## REPORT UPDATE

Application No: BR/67/25/PL

REF NO: BR/67/25/PL

PROPOSAL: Demolition of existing brick-built garages, removal of canopy structure, remediation of contaminated land and construction of 18 No. flats over 3 storeys with pitched roofs. This application is in CIL Zone 4 (Zero Rated) as flats.

Client:  
Project:  
57 Queensway, Bognor Regis, PO21 1QW  
Drawing:  
Proposed Drainage Strategy

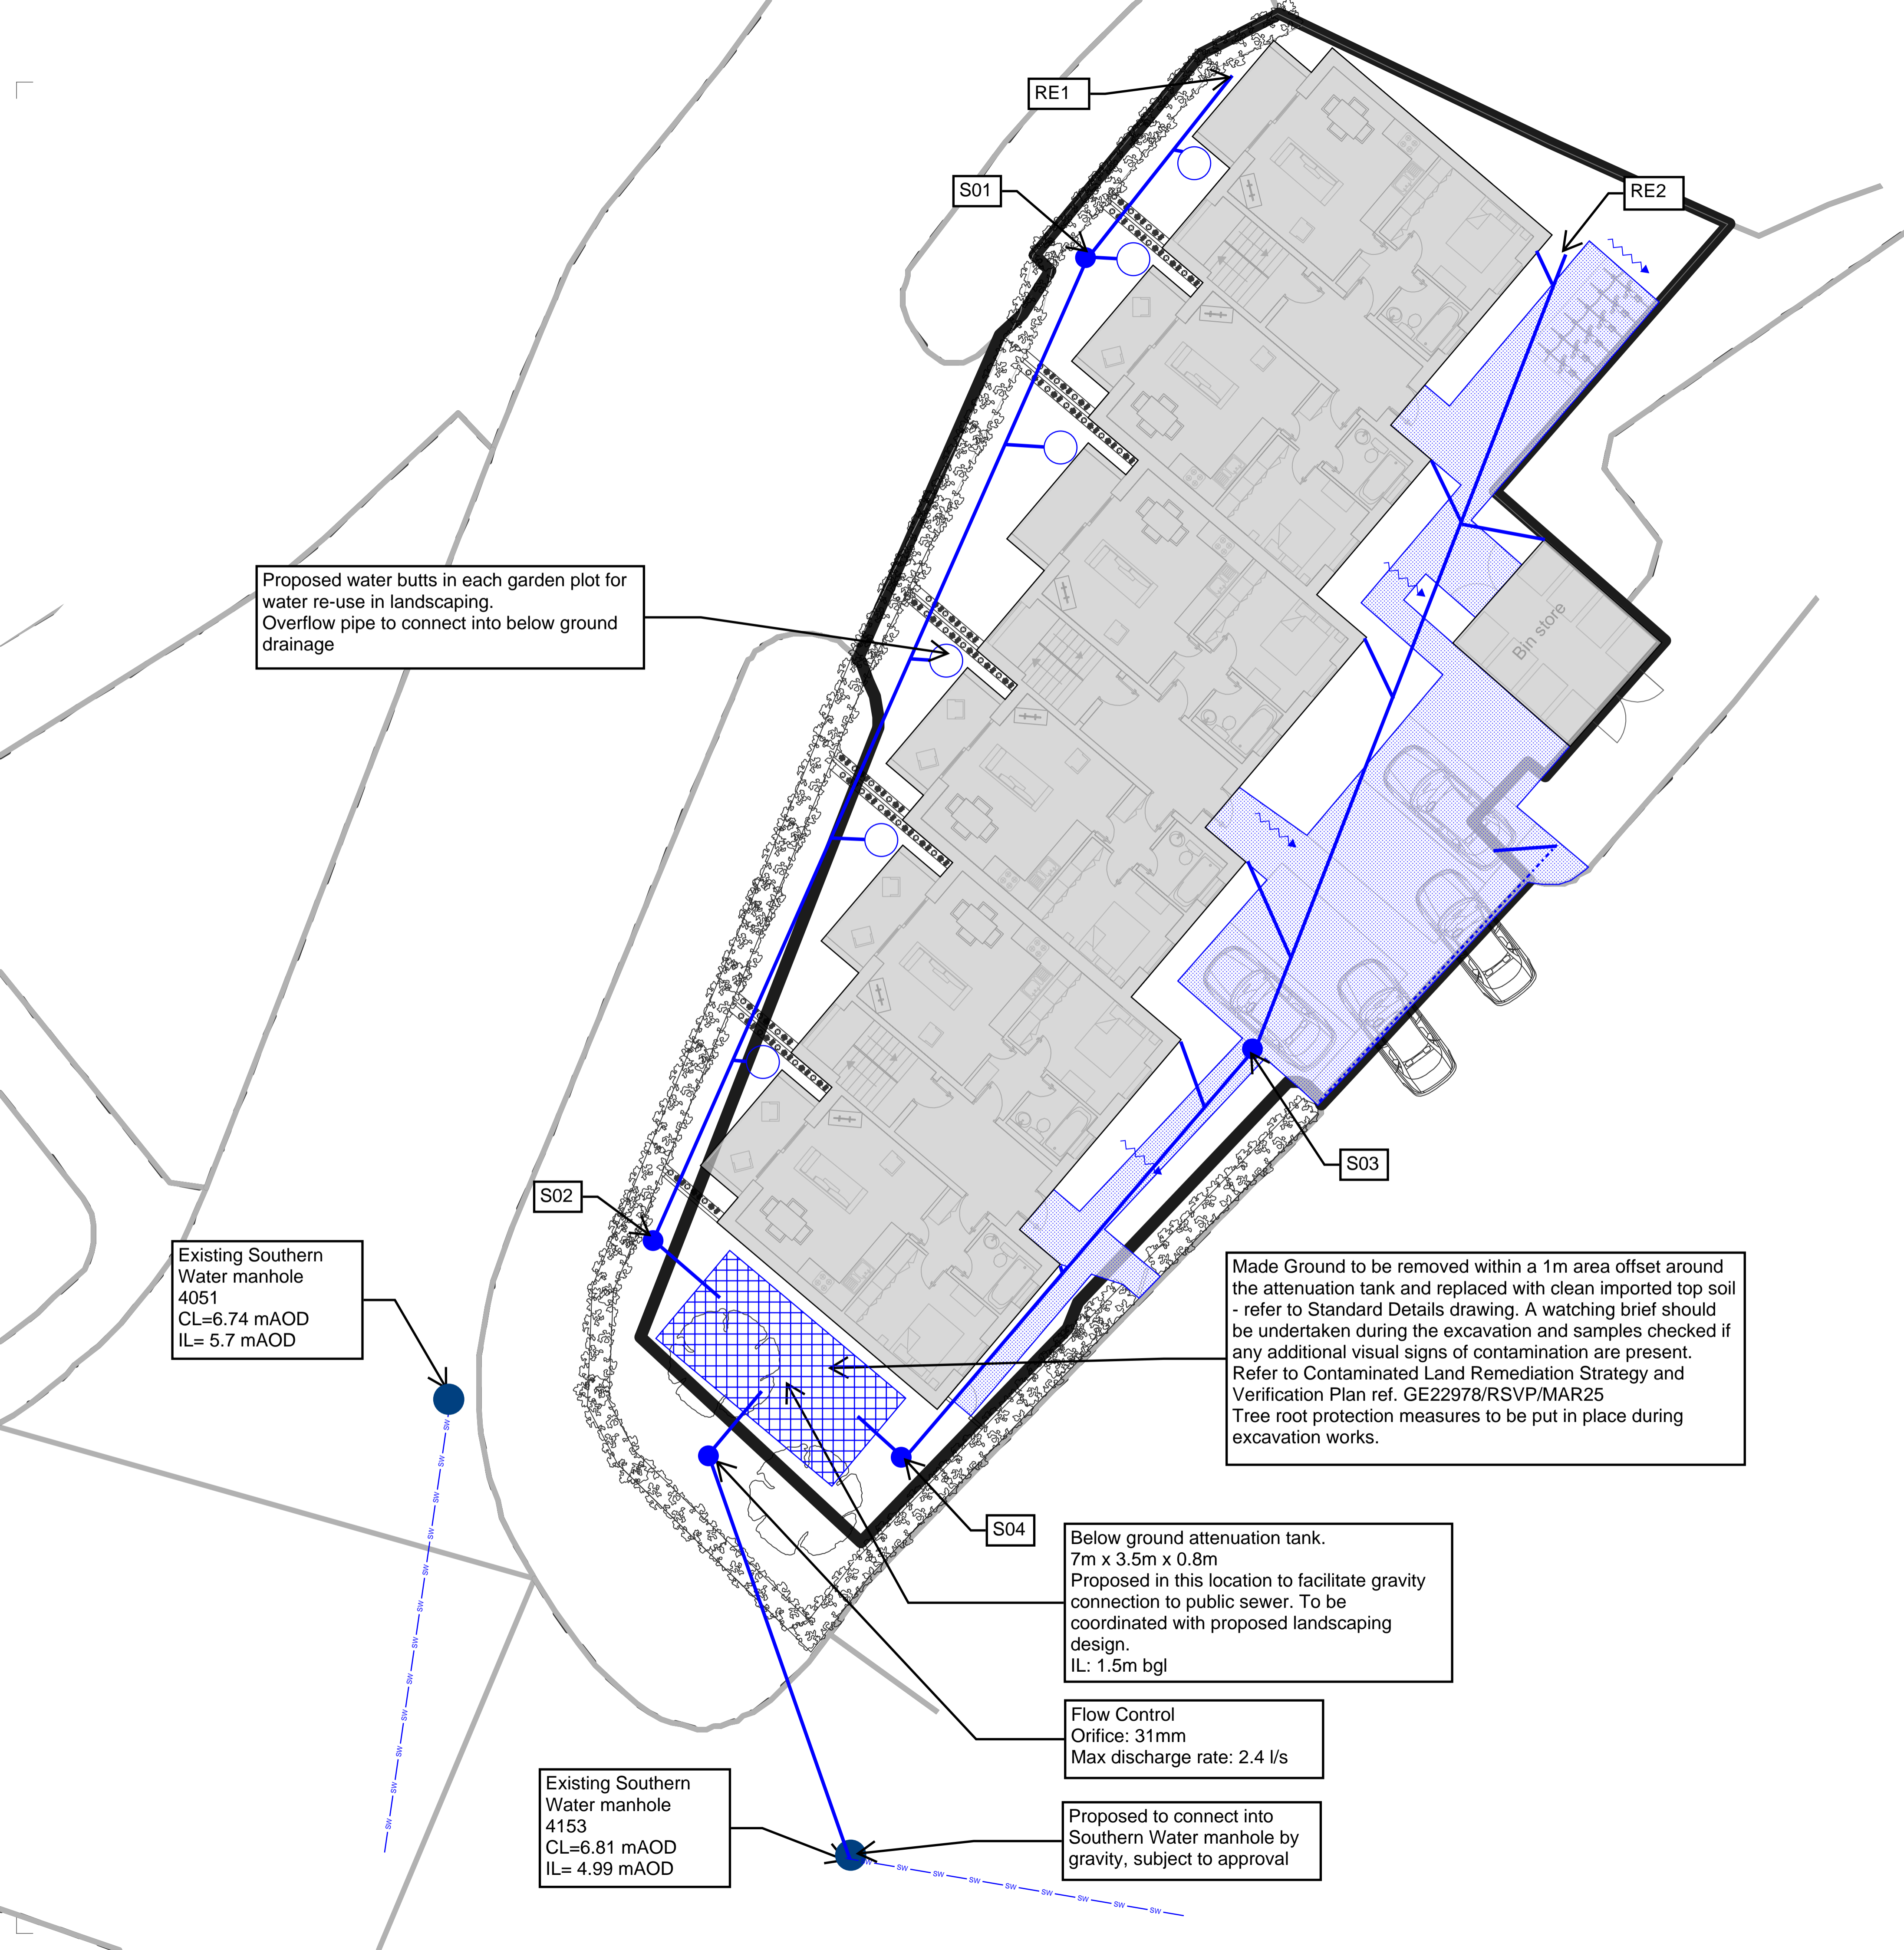
ADC Drainage - Objection. No evidence has been provided to demonstrate infiltration is not viable on site and that it should not be prioritised in accordance with the hierarchy for SuDS. If infiltration is viable there is a signification proportion of site where it may be used. The National Standards for SuDS (NSfS) is clear that the use of higher priority final destinations shall not be discounted because the site is, or was, contaminated where practical remediation strategies can be developed in conjunction with the drainage system design. This cannot be appropriately resolved through imposition of conditions.

Further comments were received following the receipt of additional information but Engineers maintain their objection. The groundwater monitoring provided shows groundwater levels at 1.07m below ground level (bgl) in November 2022. This is unlikely to be the highest potential groundwater level due to the time of year. On this basis, infiltration features are not able to meet design standards and are not viable
